**Case Officer:** Catherine Harker

**Recommendation:** Approve

**Proposal:** Internal and external alterations to an existing detached dwelling including Internal layout changes, remodelling of the front entrance porch, new dormer windows to front of main house, conversion of existing attached barn to an annex/studio and construction of a new detached garage/workshop and site landscaping

Drawing Title:  
Proposed South & East Elevations

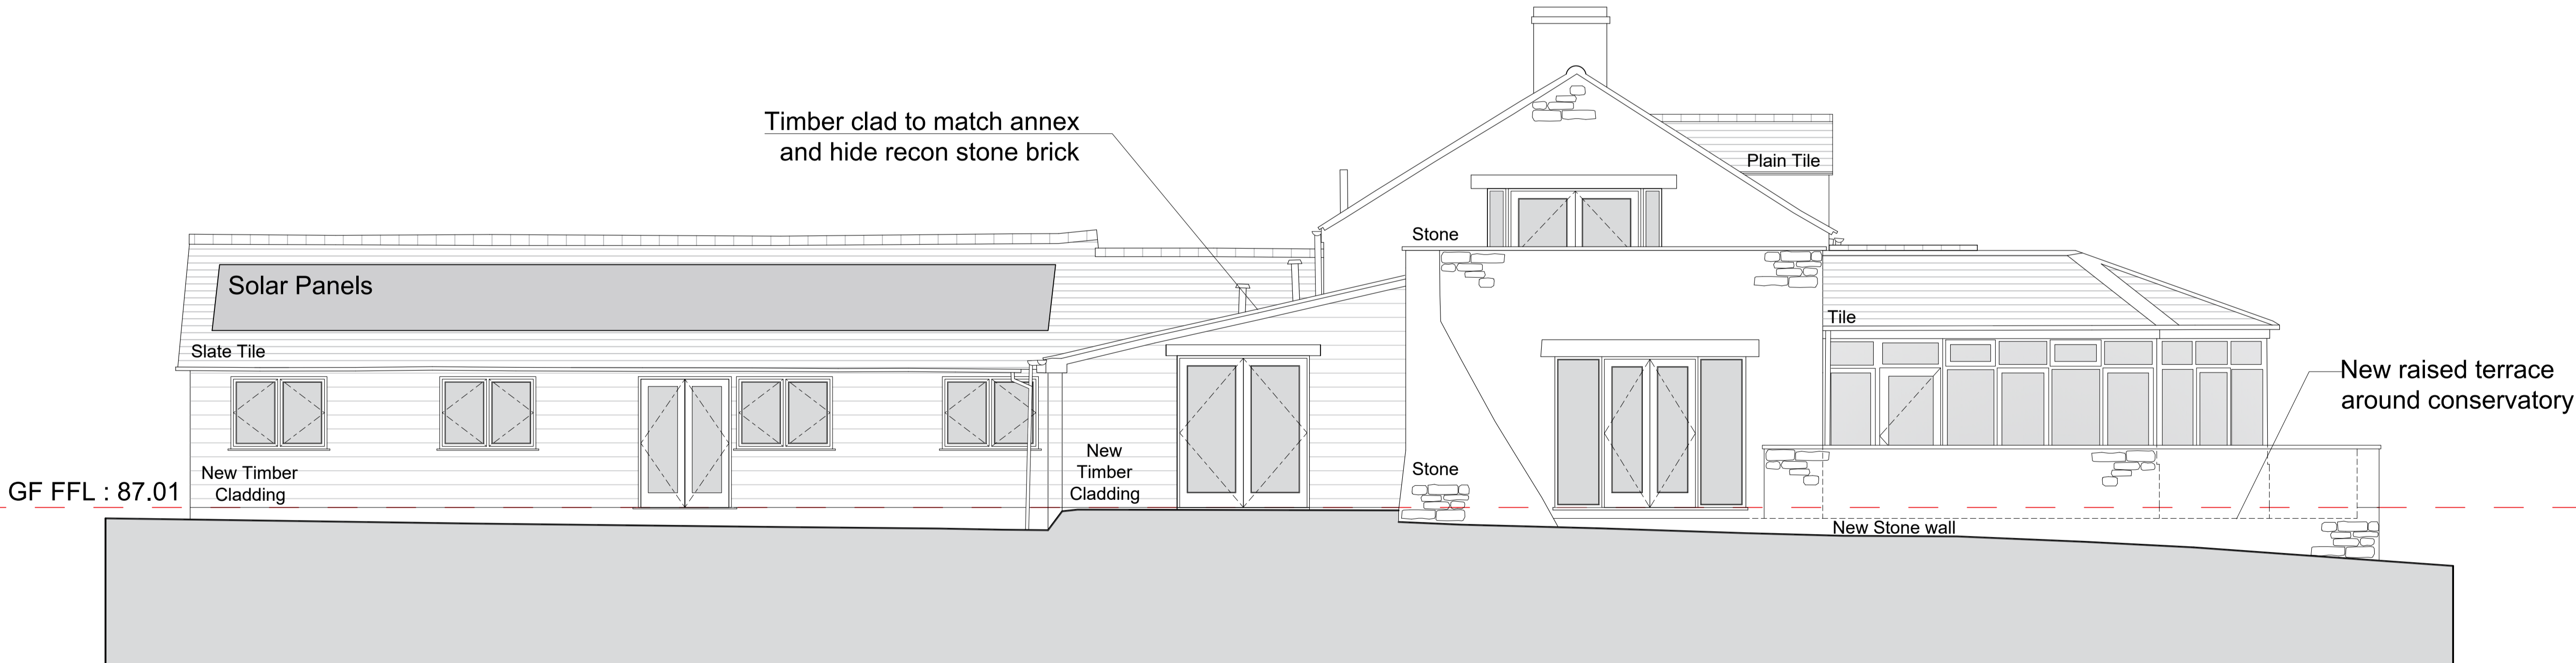
The dormers on the east elevation are reasonably small, and subservient to the dwelling. The design is not ideal, since they would rise straight up from the wall, rather than being set within the roofslope, which has a somewhat incongruous

appearance. However, due to their orientation, facing east, compared to the road to the north, and the screening and speed of the road, it is considered that they would not be noticeable from the road and would not harm the visual amenity of the area.

The louvre window between the 2 dormers would be slightly incongruous in design, but again would not be readily visible from the road and would not harm the visual amenity of the area.

The porch would be reasonably subservient to the dwelling and would not harm the dwelling compared to the existing porch.

Some minor alterations are proposed to the existing fenestration, such as reinstating a window on the north elevation and changing a window to the door on the south elevation, but these are not considered to harm visual amenity.

Drawing Title:
Proposed Garage Elevations

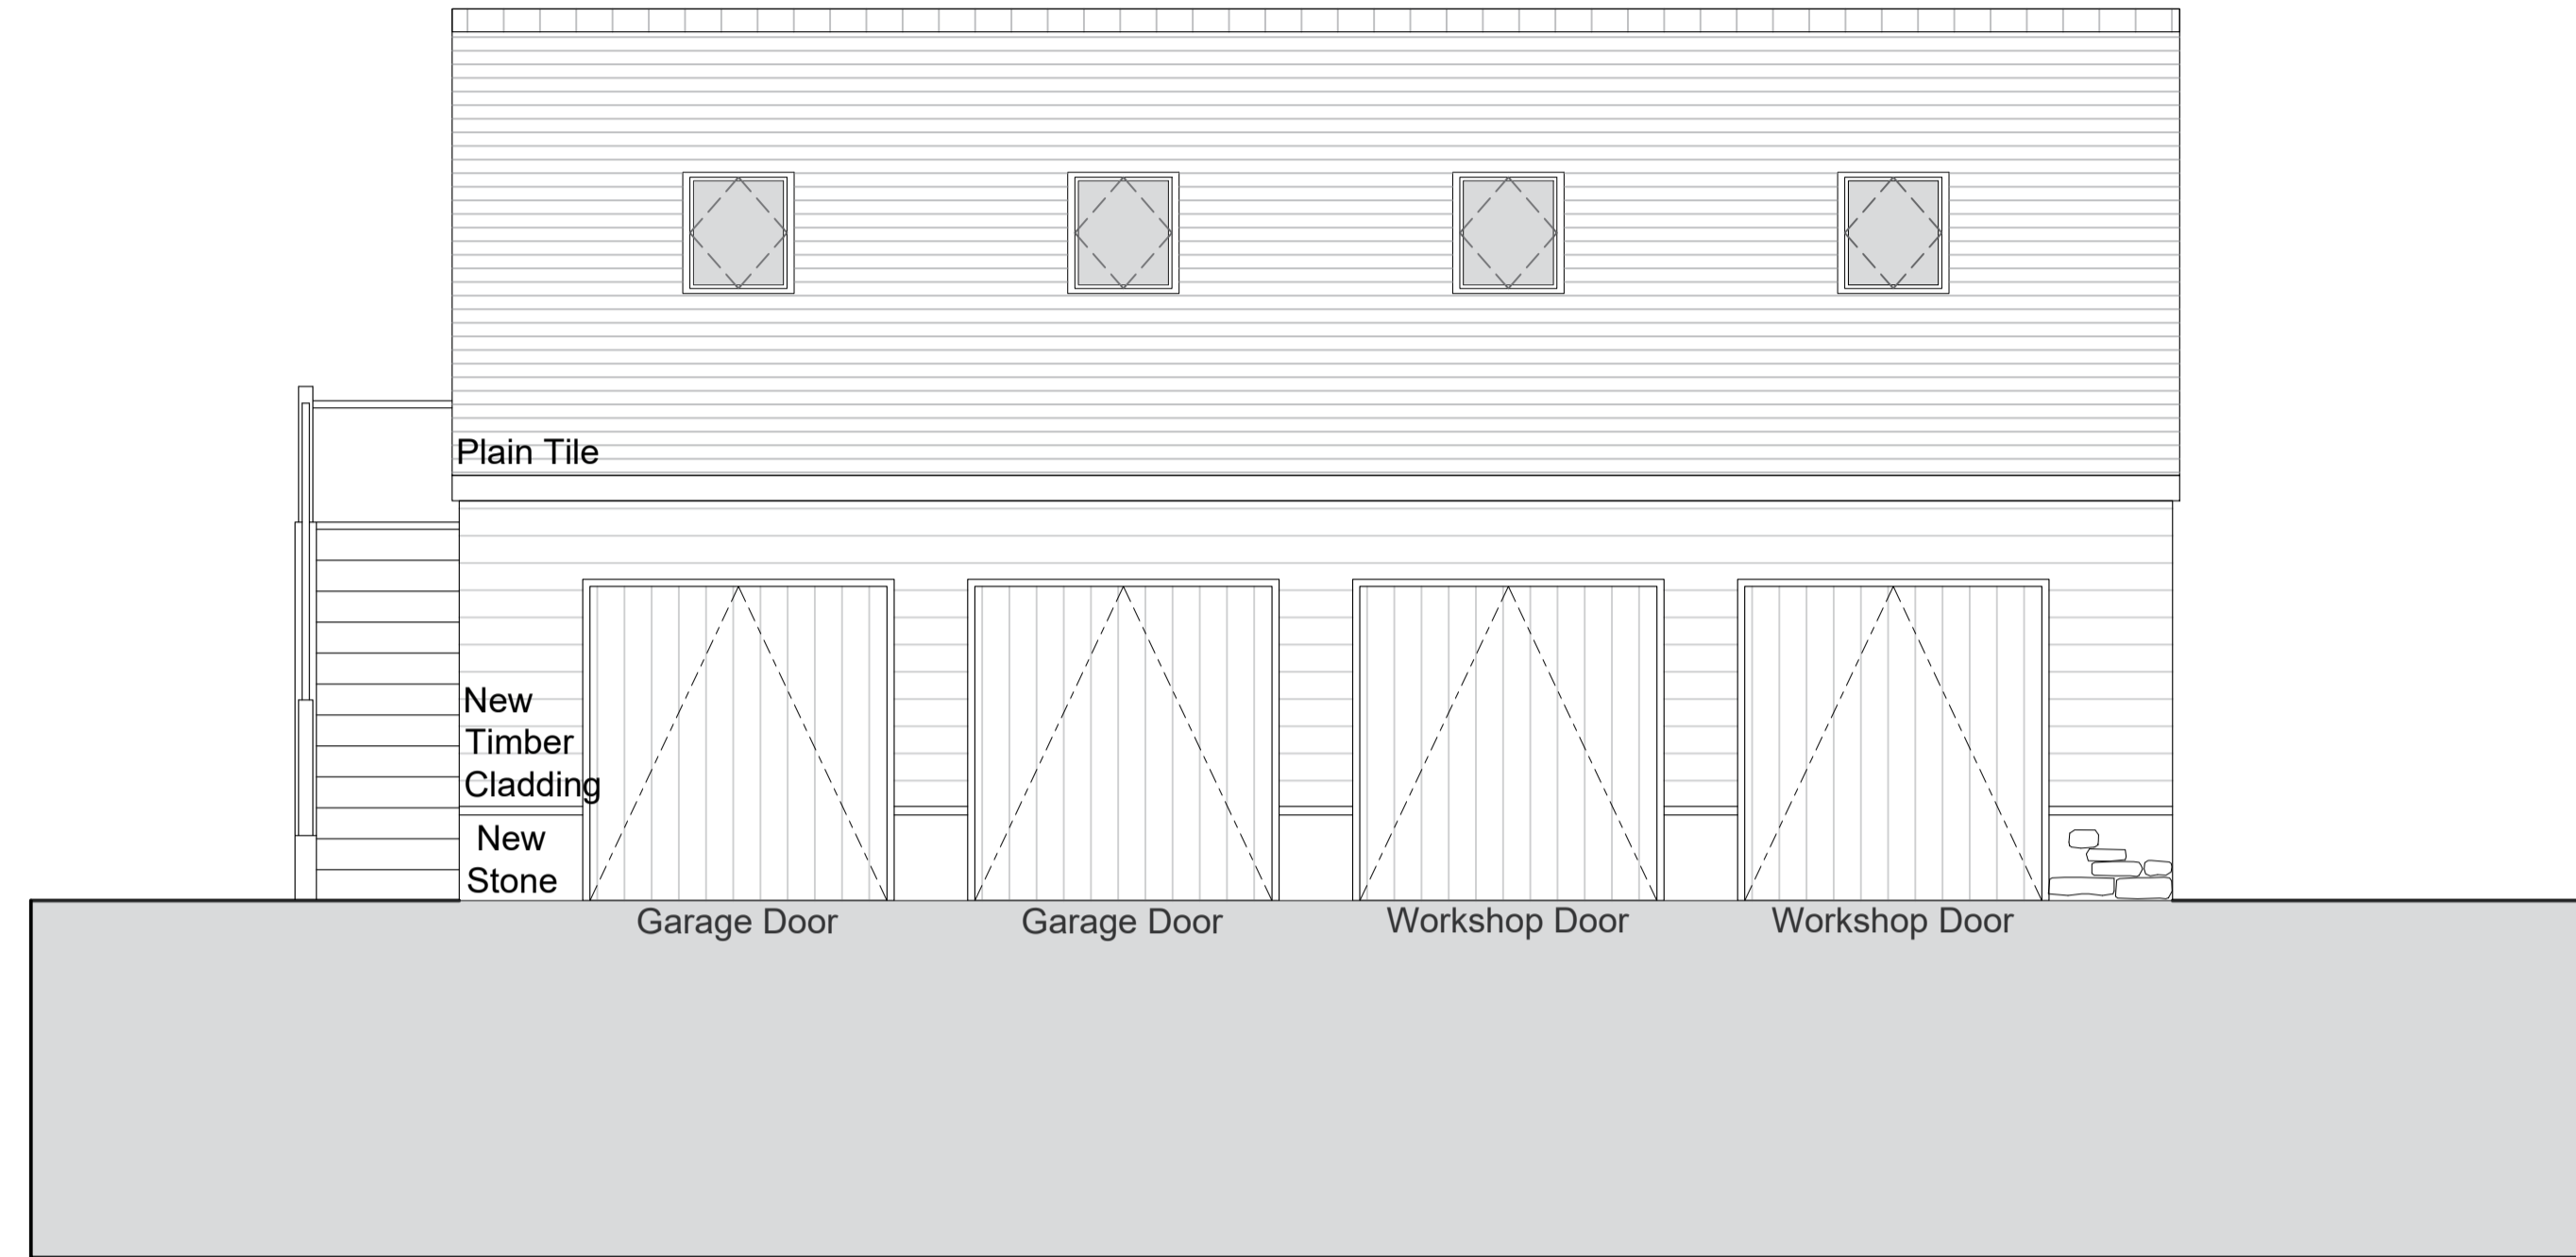
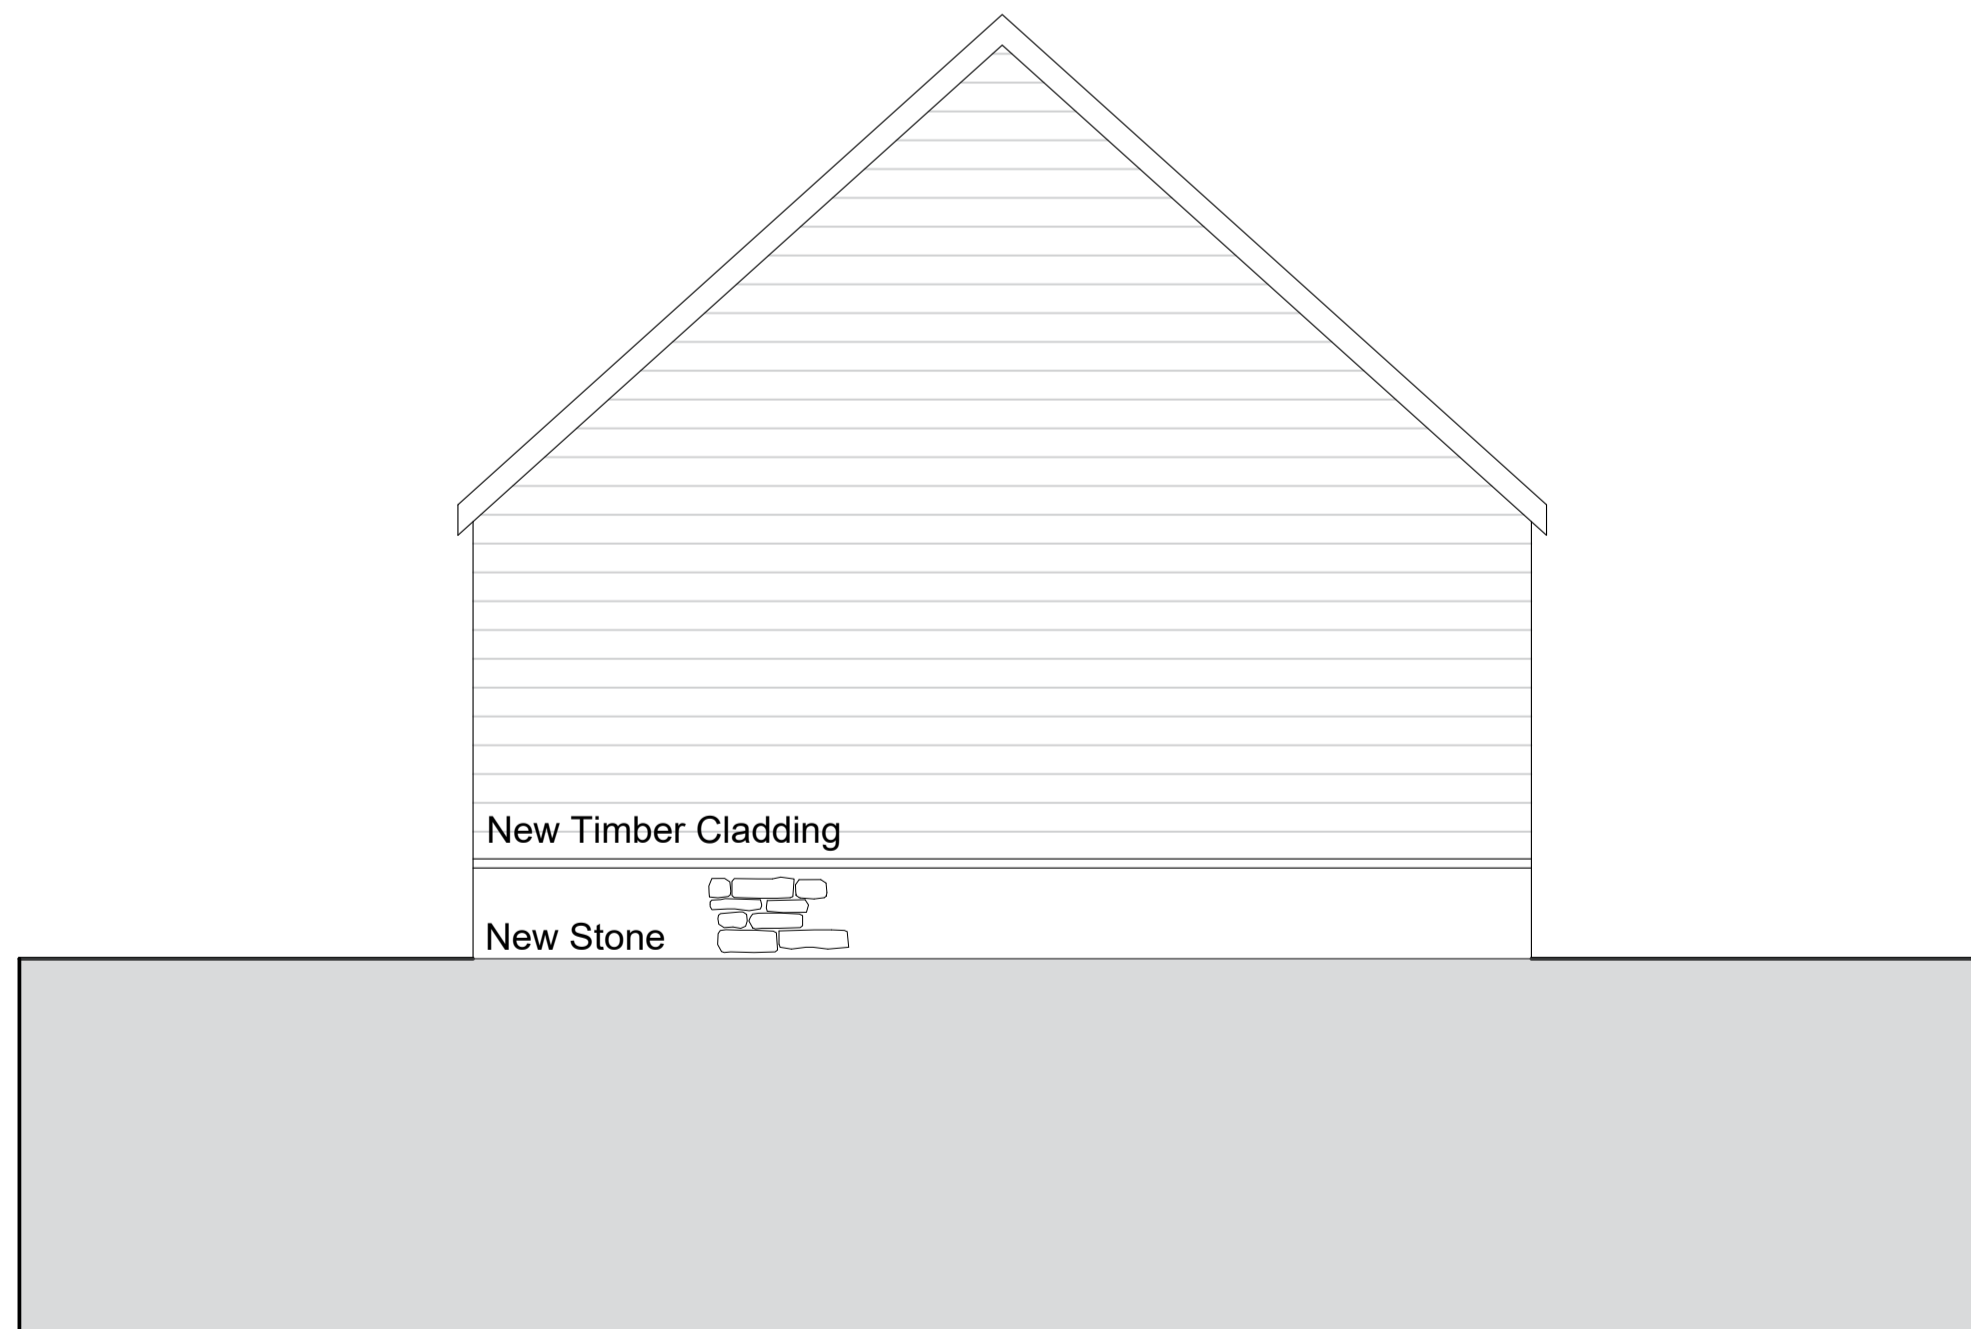
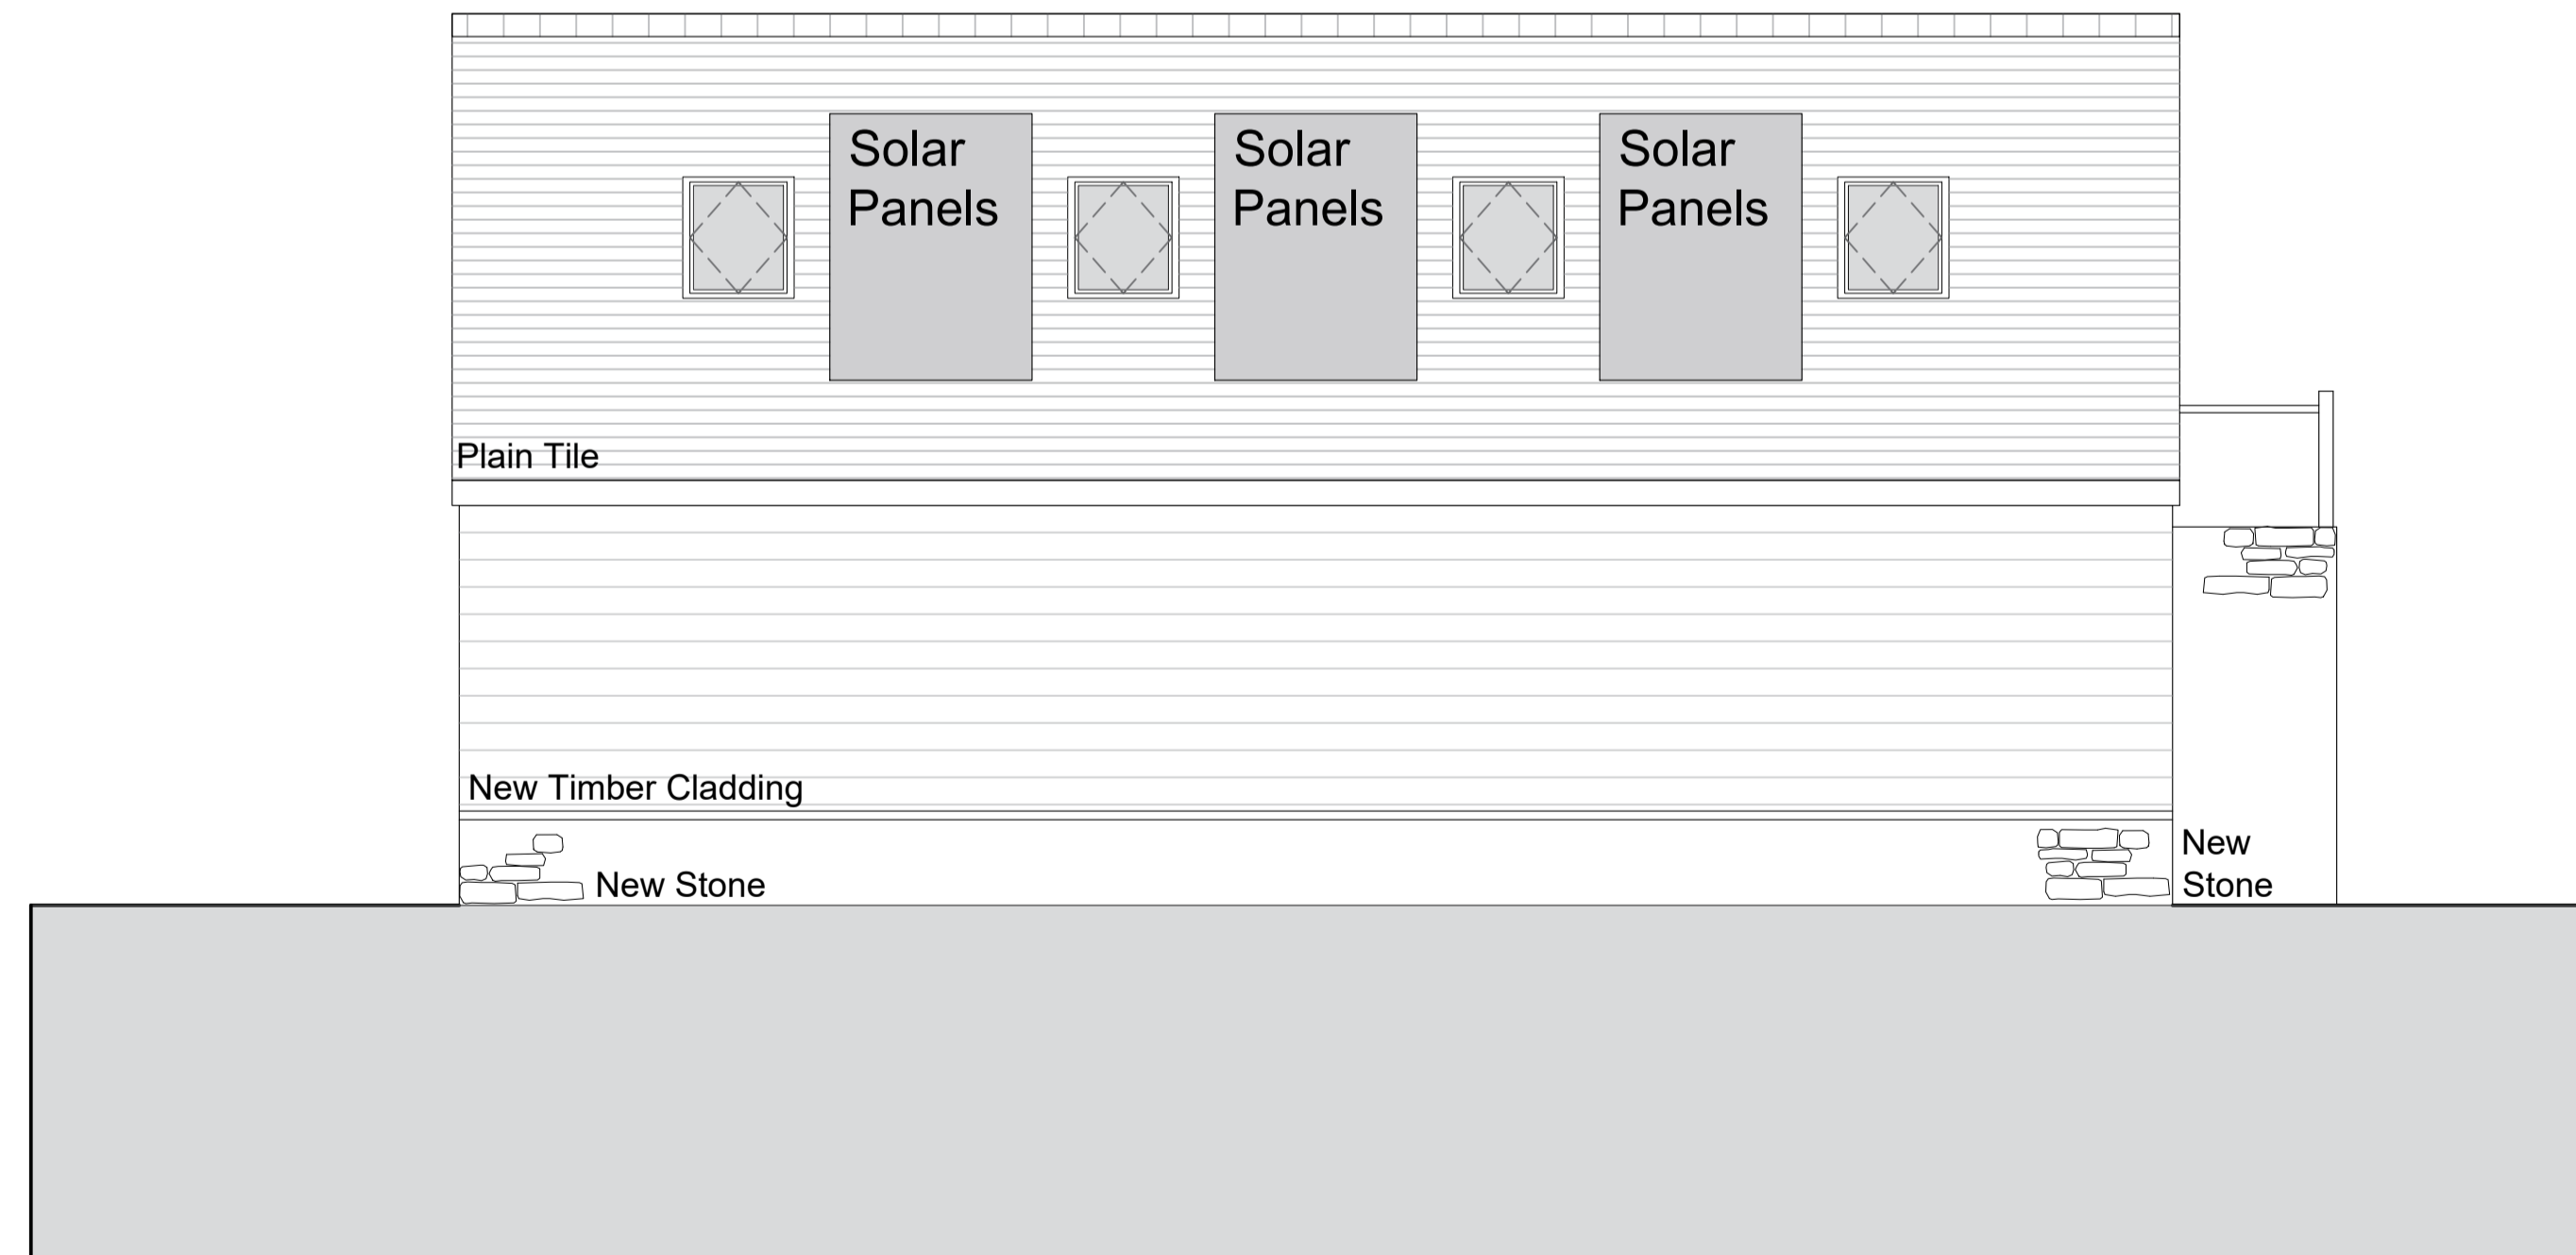
The proposed garage would be approx. 7m x 12m x 6m high. This is quite large, but it would still be subservient to the much larger sprawling dwelling, and would not be readily visible from the road, being screened by the host dwelling, attached barn and neighbouring buildings. It would not harm the visual amenity of the street scene.

The proposed garage would be adjacent to the boundary with Rectory farmhouse, but would be 22m from the house, and would not result in a significant loss of light or outlook to the house. The rooflights would face the sky and would not result in significant overlooking.
